Subject: Land the rear of Highground House and Orchard End Barnham - BN/28/22/DOC

Planning Application Reference: BN/28/22/DOC

Proposal: Approval of details reserved by condition imposed under BN/114/21/PL relating to conditions 3-schedule of materials and finishes, 4-renewable energy, 6-Construction Management Plan, 8-bin storage, 10-covered and secure cycle parking spaces, 11-electric vehicle charging points, 12-surface water drainage, 14-foul water drainage and 17-external lighting.

PROPOSED BLOCK PLAN 1:500 @A3

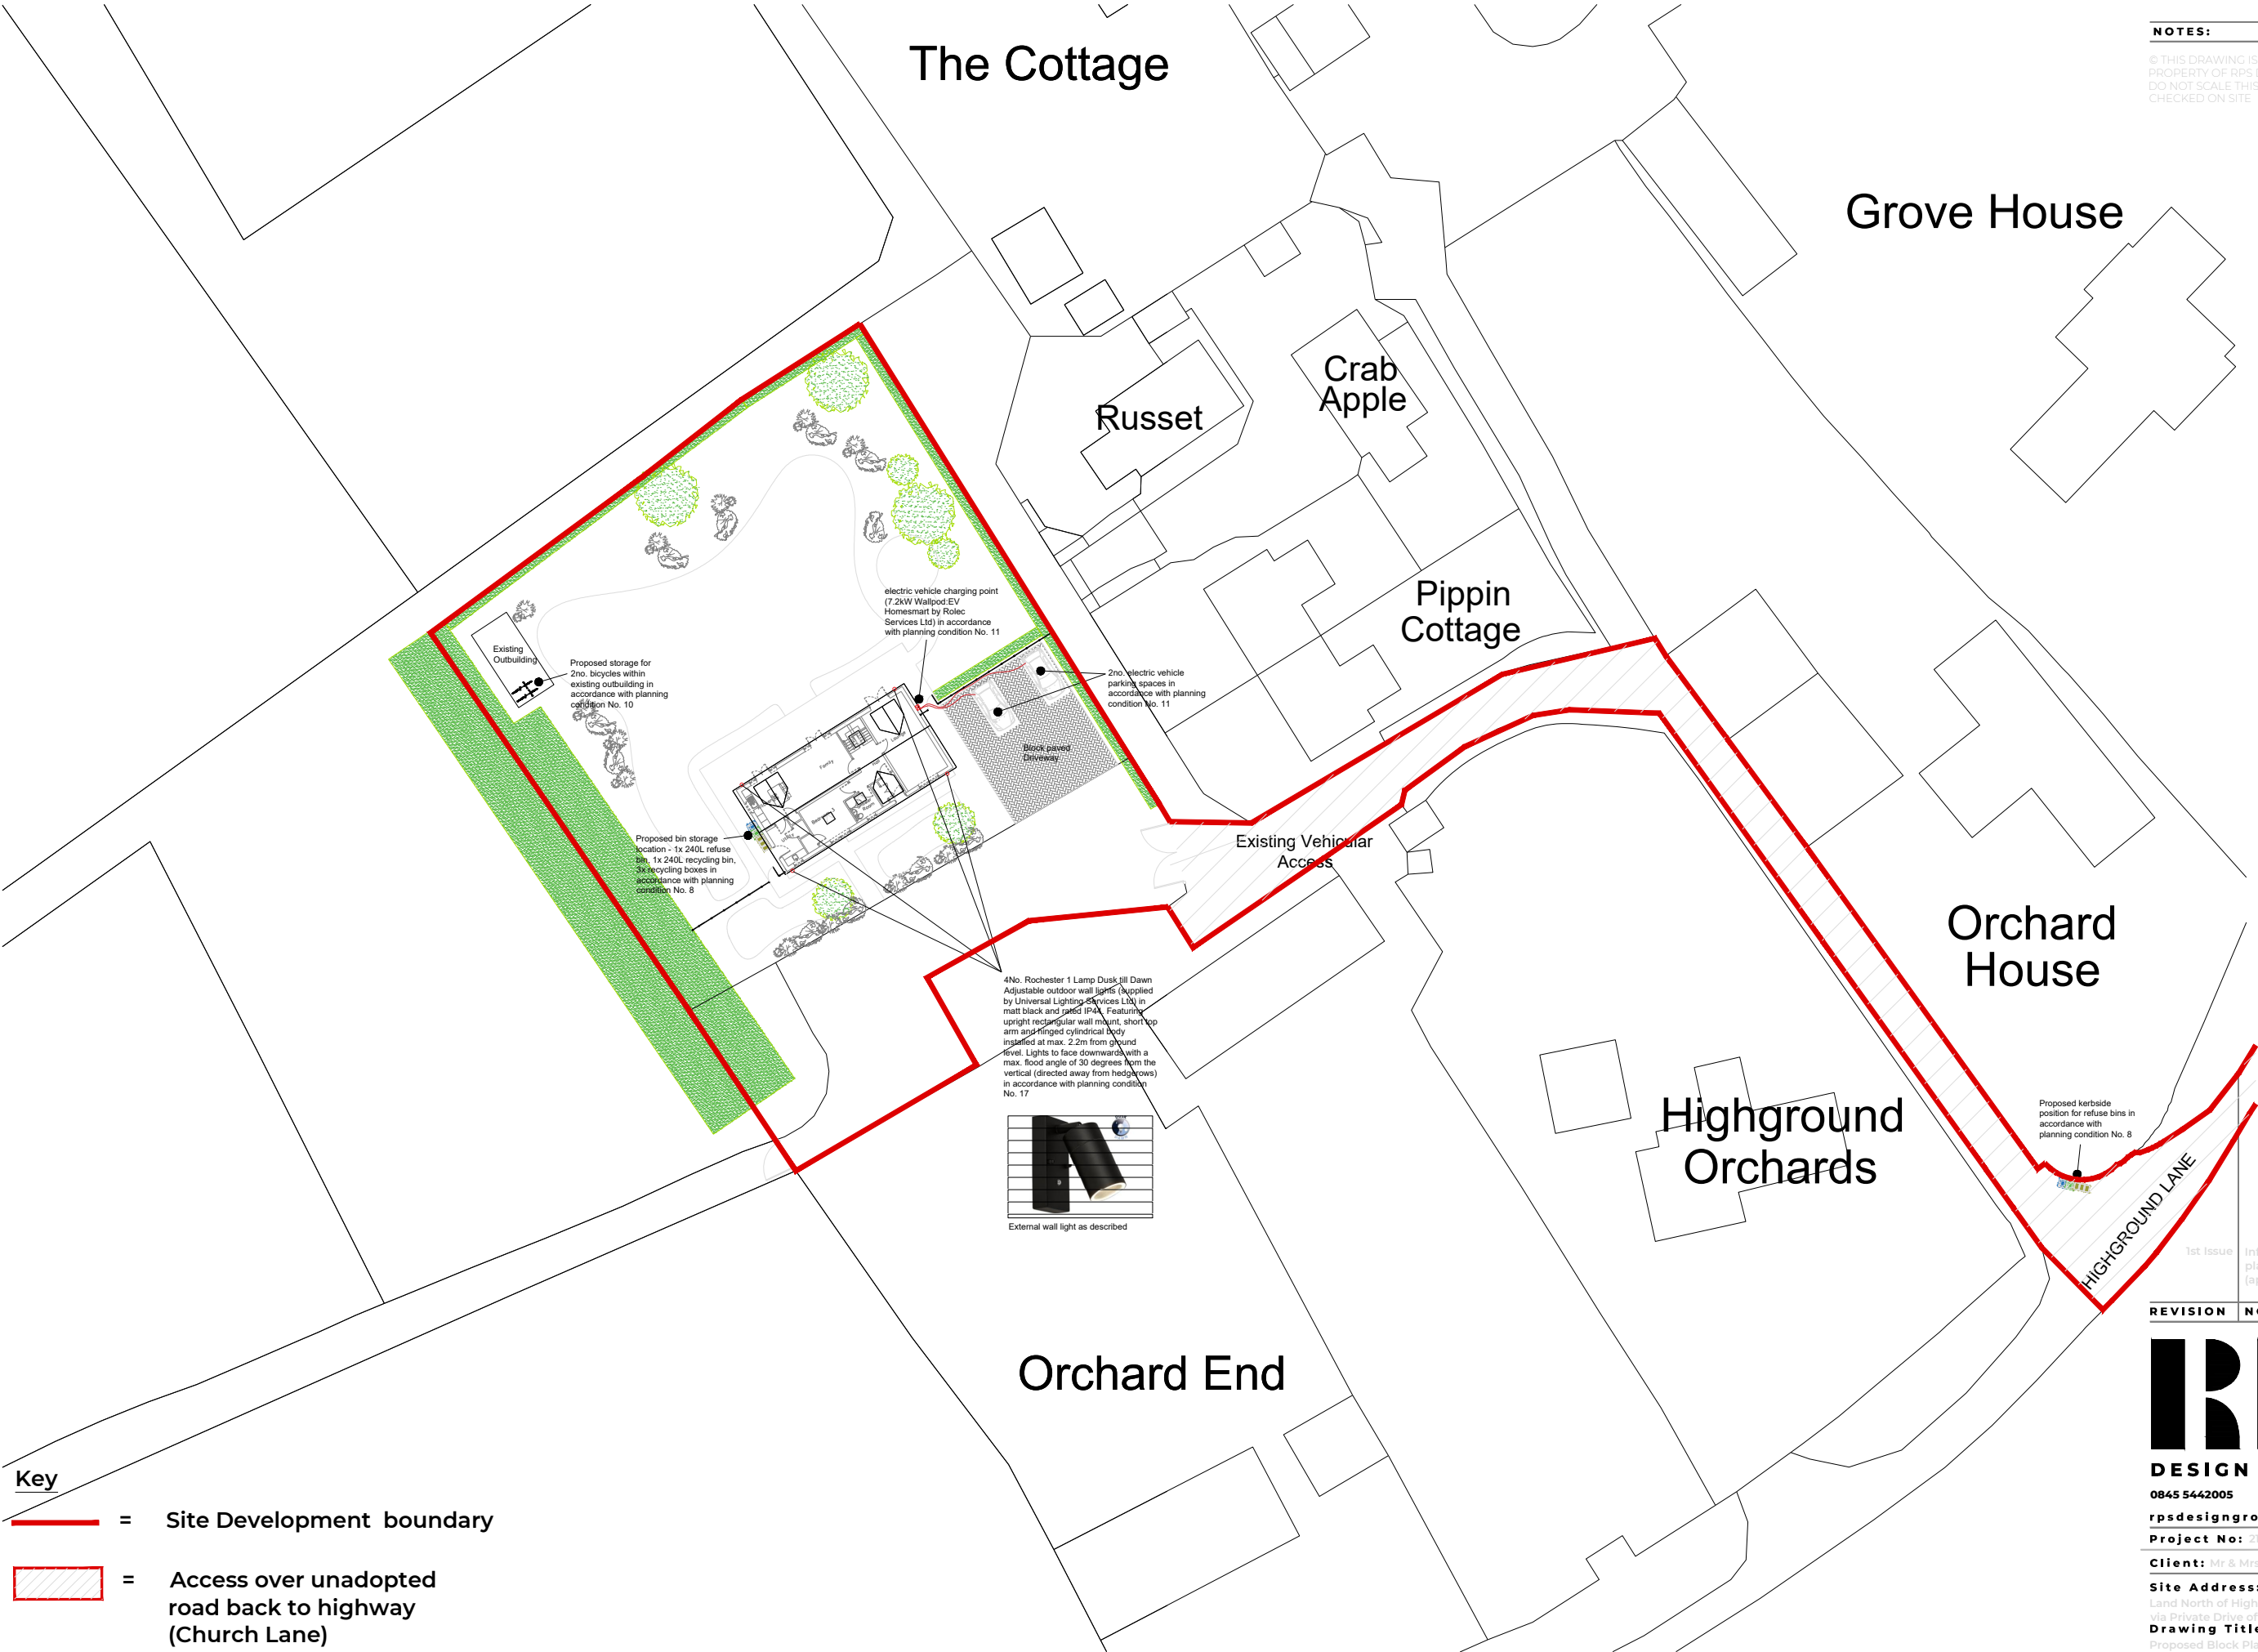
Having reviewed the document entitled 'EV Charging Information | Wallpod:EV Homesmart EV | Universal Socket 3.6 kW or 7.2 kW' [produced by Rolec EV Charging] and the document entitled 'Proposed Block Plan' (no date) [produced by RPS Design Group] I note there is no indication as to whether the proposed charging points are in accordance with BS 8300-1:2018, which considers the needs of EV drivers who may be disabled or have mobility issues. This is listed as part of the minimum technical specification for the government's Electric Vehicle Home Charging Scheme.

I therefore request the applicant provides documentation to demonstrate the proposed EVCPs are in accordance with BS8300-1:2018 to enable the condition to be discharged.

Having reviewed the document entitled 'Proposed Block Plan' (no date) [produced by RPS design group] I am satisfied the requirements of the condition have been met. I therefore recommend the condition may be discharged, provided the development proceeds in accordance with the RDS block plan diagram.
